Examining Authority's Third Written Questions

Questions for EA Response

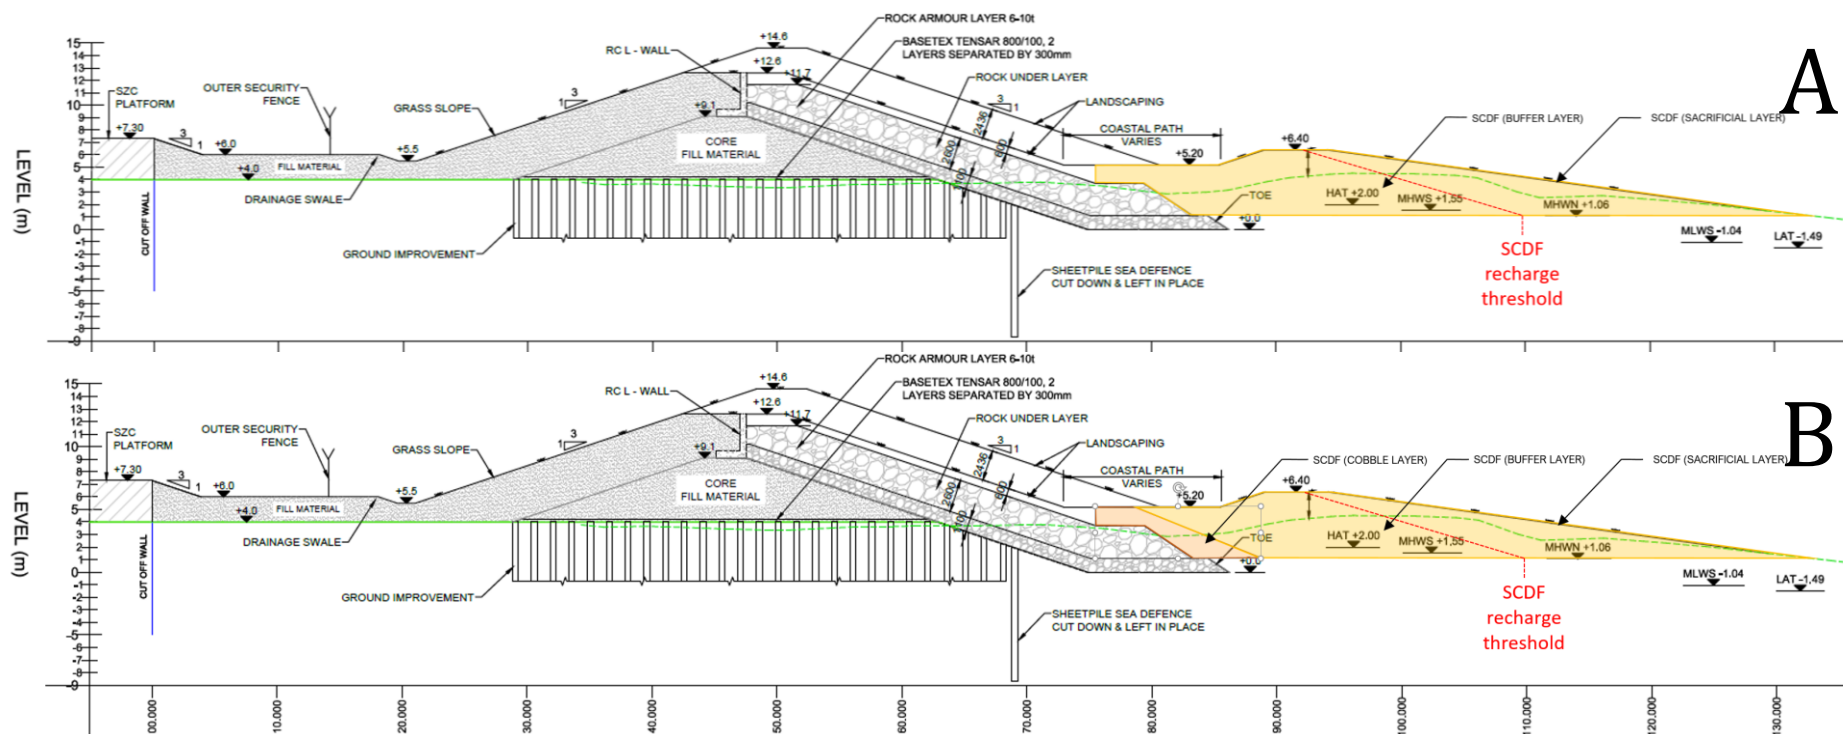
Cu.3 Cumulative impact			
Cu.3.0	The Applicant, EA	<p>Cumulative impacts of coastal processes: The EA's post hearing submission of oral case at ISH6 [REP5-149] states that with regard to the BLF, HCDF and SCDF it cannot scrutinise cumulative impacts at this stage because of outstanding modelling – adapted HCDF design and morphodynamics of SCDF beyond 2099 – required to inform their position. The same applies to in-combination impacts with other projects such as EA1 and 2.</p> <p>(i) In the light of information provided by the Applicant at DL7 can a response on cumulative impacts now be provided?</p> <p>(ii) If not, what further information is required?</p> <p>(iii) The Applicant is requested to summarise and update its position in relation to cumulative impacts in the light of the latest information that has been submitted.</p>	<p>(i) The information provided at DL7 extends some elements of the coastal processes and geomorphology assessment to 2140, but further work is anticipated to complete the assessment for the full range of plausible scenarios.</p> <p>(ii) We require additional work to consider the following in order to fully assess the risk of cumulative impacts to coastal processes:</p> <ul style="list-style-type: none"> - Modelling of the Beast from the East sequence to 2140 (including for the adapted HCDF design and receded shoreline scenario) - Modelling the 1 in 10,000 year safety case event to 2140 (for the full range of scenarios) - Detailed final design information for the SCDF and HCDF

CG.3 Coastal Geomorphology			
CG.3.2	ESC, EA	<p>Impacts on coastal processes: The Applicant accepts [REP5-118] that recent modelling shows during and beyond decommissioning the SCDF maintained</p>	<p>We are satisfied that the mitigation measures outlined in the CPMMP should be sufficient to address this risk, providing planned additional</p>

<p>coast could become a foreland and even though it is releasing sediment, the SCDF may begin to disrupt longshore sediment transport. It states that this matter is in hand as it has the right monitoring to detect whether there has been a blockage and three mitigation methods for beach maintenance are planned to correct that. A section in the CPMMP [REP5-059] has been added to more explicitly reflect this point. Please confirm that it is agreed that the CPMMP revision achieves that objective and that the monitoring, mitigation methods and triggers set out in section 7 are satisfactory and agreed?</p>	<p>modelling work continues to show that coastal change risk remains at a manageable level.</p> <p>We retain some minor concerns relating to the potential preferential use of coarser particle sizes when designing the SCDF and beach recharge compositions (as outlined in section 7.5.3 of the CPMMP), as this could have adverse environmental impacts and alter the geomorphology of the Sizewell frontage, even if by simply skewing the mean size towards the coarser end of the natural distribution. However, we note from recent discussions with the applicant that this concern has been recognised, and that use of a particle size distribution which mimics the native conditions is expected to be viable from an engineering perspective, which is welcome. We anticipate further discussion around this point as work to develop the CPMMP (particularly mitigation options) and SCDF design continues.</p> <p>We also note that discussions remain ongoing regarding the governance and enforcement arrangements for the CPMMP. We consider it critical that all parties agree a robust approach to these matters in order to avoid future uncertainty or conflict, and ensure the CPMMP provides a viable and deliverable adaptive management plan.</p>
